**Subject: The New Sydney Fish Market – Stage 2 MOD 6 (SSD 8925)**

Thank you for your e-mail received 3 December 2021, requesting input from Environment, Energy and Science Group (EES) on the New Sydney Fish Market – Stage 2 MOD 6.

The modification application seeks to temporarily extend the boundary of the site to include the Sydney Secondary College car park at 1 Pyrmont Bridge Road, to be utilised as temporary site accommodation (site sheds and amenities) during the construction of the new Sydney Fish Market.

Figure 7 Gantry layout with staged installation

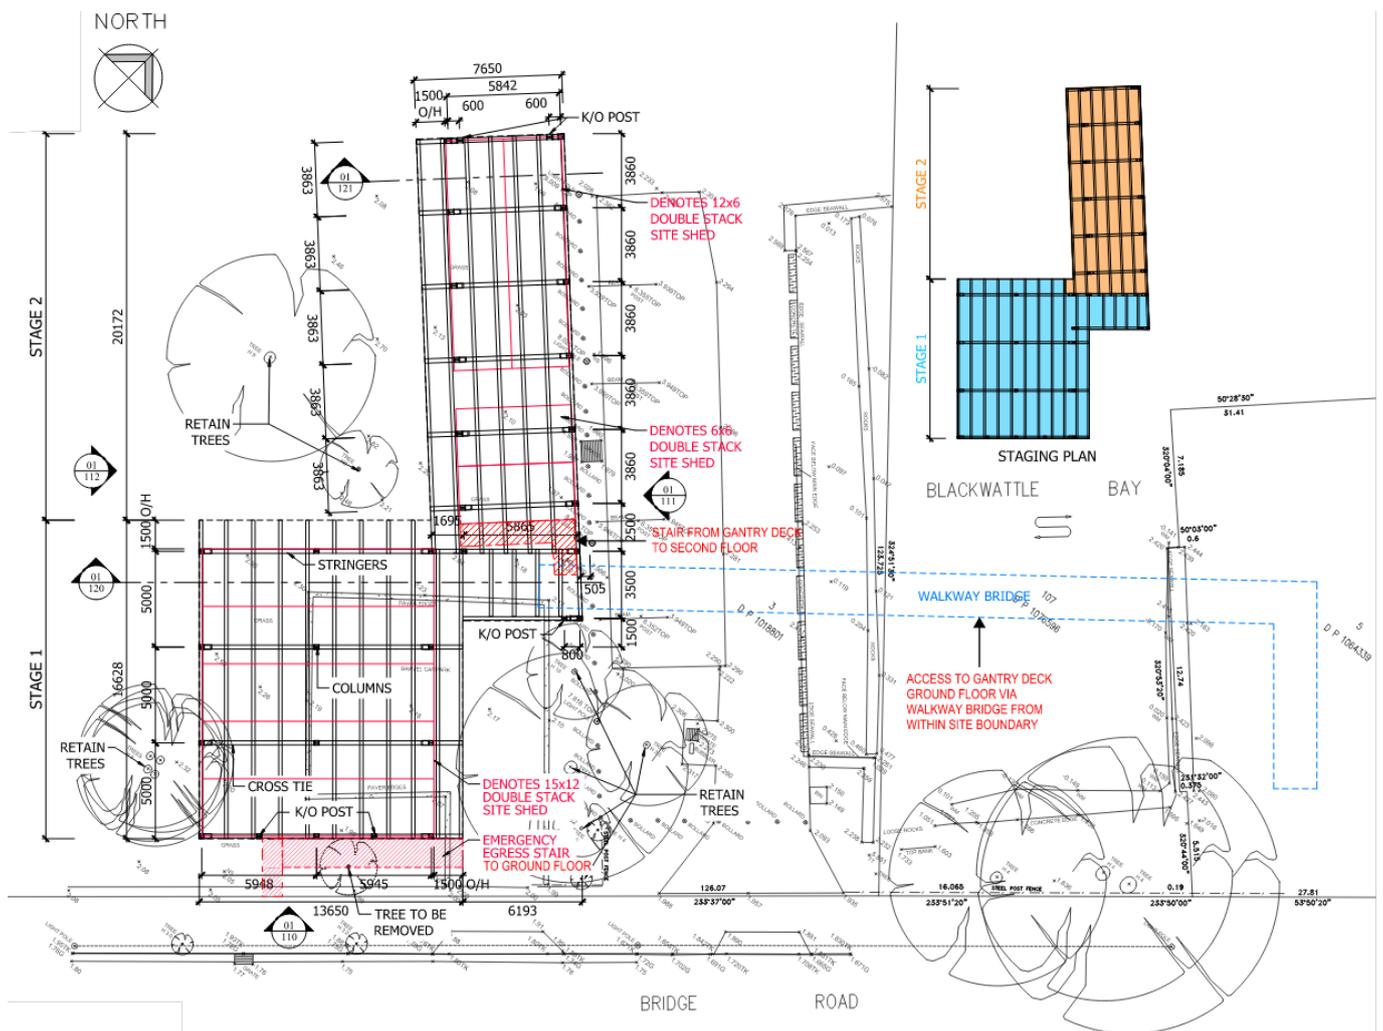
With the above noted, one high value tree, identified as tree 11 in the Arboricultural Impact Assessment prepared by Hunter Bruce Tree Consulting, will be subject to encroachment into its tree protection zone (TPZ). The report notes that *‘three (3) x screw piles are required in the TPZ area (as shown in figure 7) however this is unlikely to have any impact on the tree provided exploratory non-destructive excavation is carried out before the screw piling to ensure major roots are not damaged’*.

This statement assumes there is flexibility in the placement of the proposed screw piles and that if significant roots are identified the screw piles may be moved to another root free location. This assumption should be confirmed and if incorrect, the necessary root investigation should be undertaken now to determine if any amendment is required to the positioning of the proposed gantry deck to ensure the tree is not impacted.
